7 February 2022

**RE: PROPOSED MIXED USE DEVELOPMENT – EDEN STREET & PRINCESS HIGHWAY, ARNCLIFFE
BCA COMPLIANCE STATEMENT FOR DA SUBMISSION R7**

This report has been prepared based on a review of the preliminary DA architectural plans prepared by Group GSA:

1 GA - LV 2
1:250

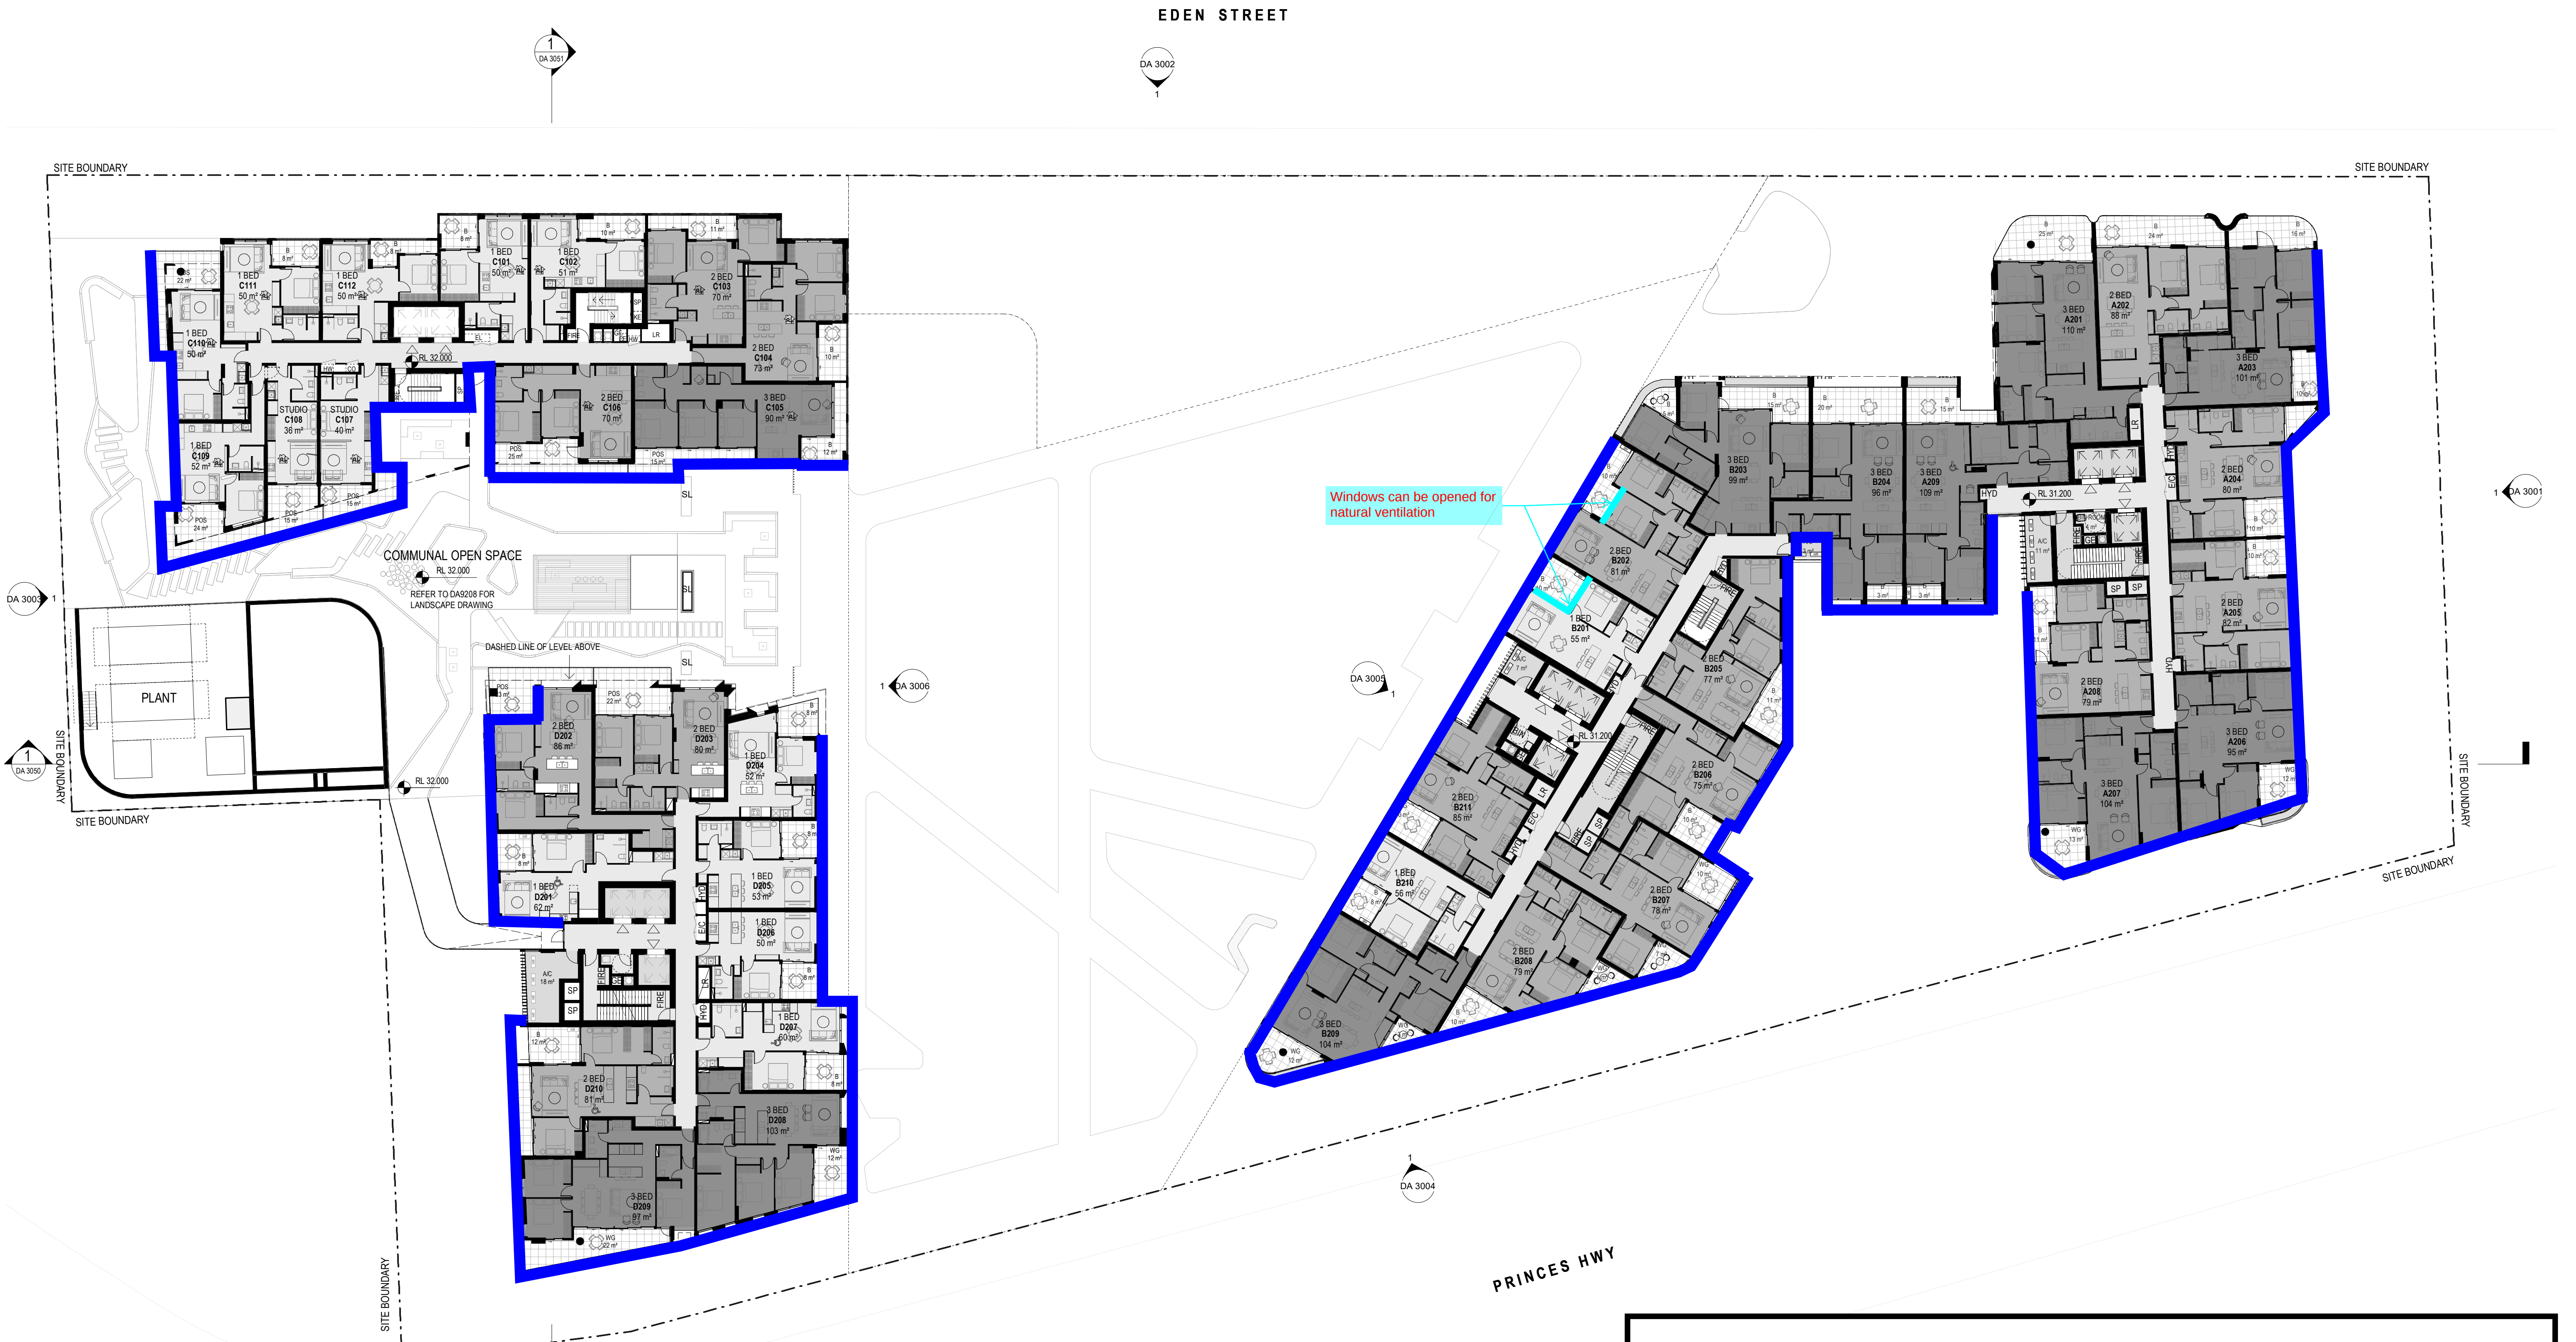
The external wall of the plant room on Level 2 between Building C and D is exposed to the southern boundary and will need to be fire rated and any openings protected;

Level 2 Southern plant room exposure to site boundary.

Scale Project No Drawing No Issue
1:250 180319 DA 2005 D

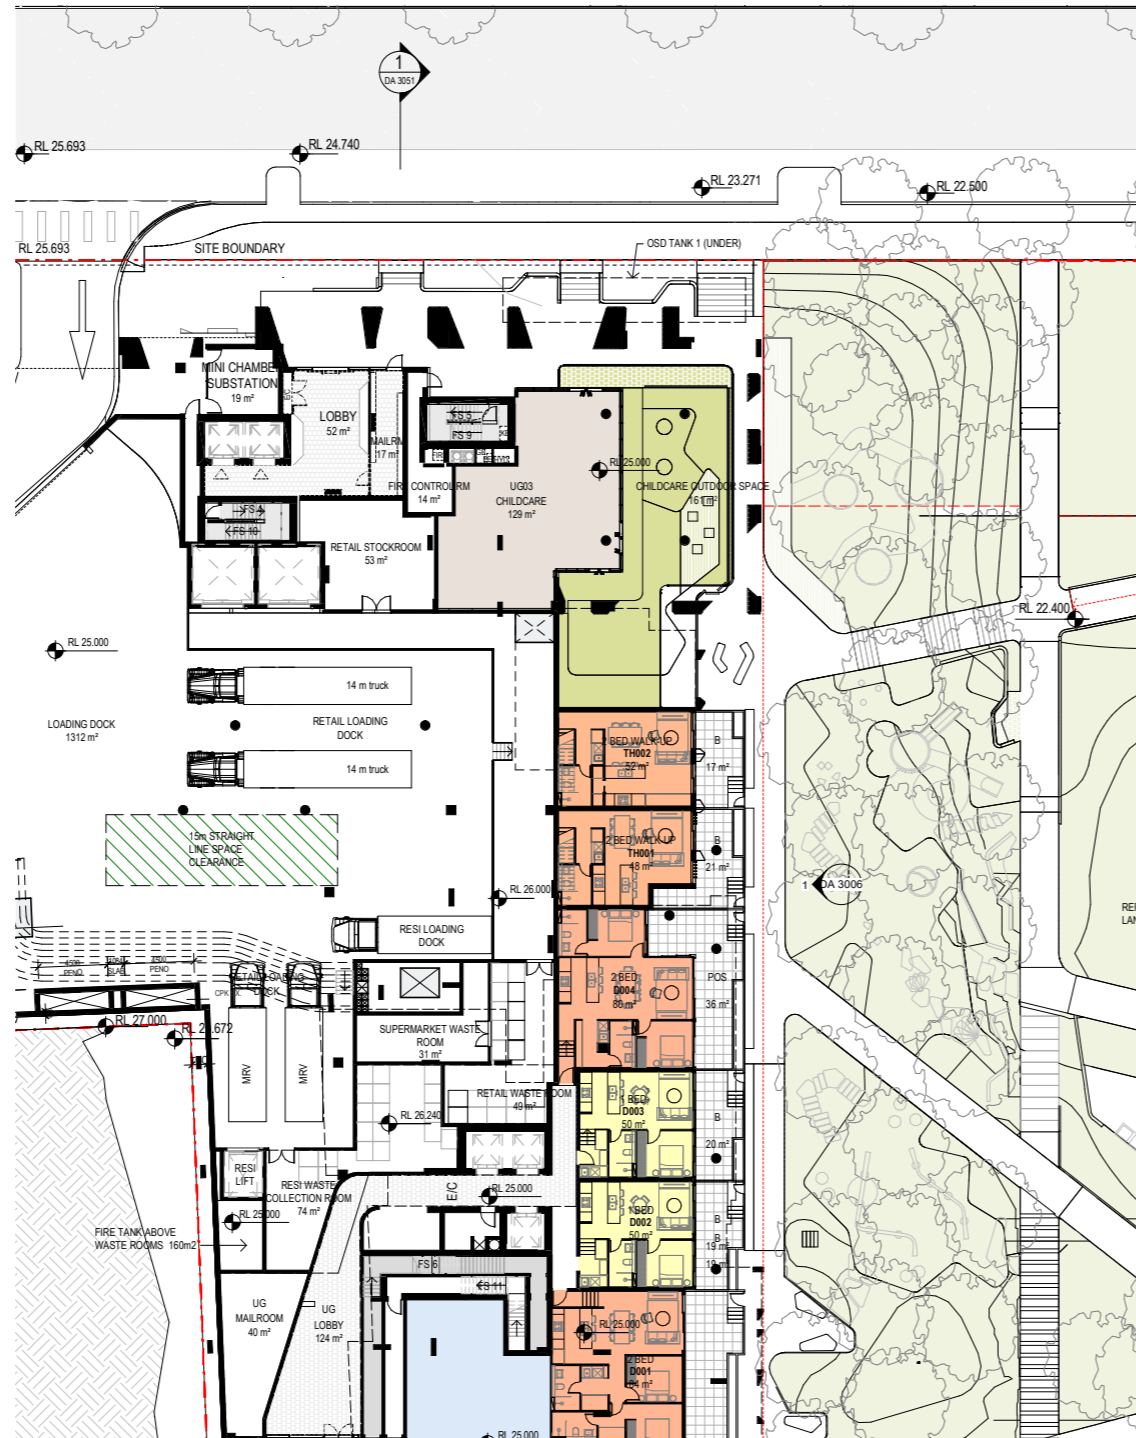
There are openings in adjoining fire compartments between the Upper ground lobby and the adjoining retail compartment, and the mini chamber substation and loading dock. As such, protection of external wall and associated openings in different fire compartments is required in accordance with C3.4.

10. D3.2	<p>Clarification is required as to how equitable access is proposed to the residential lobby of building AB noting that no ramps have been proposed.</p>
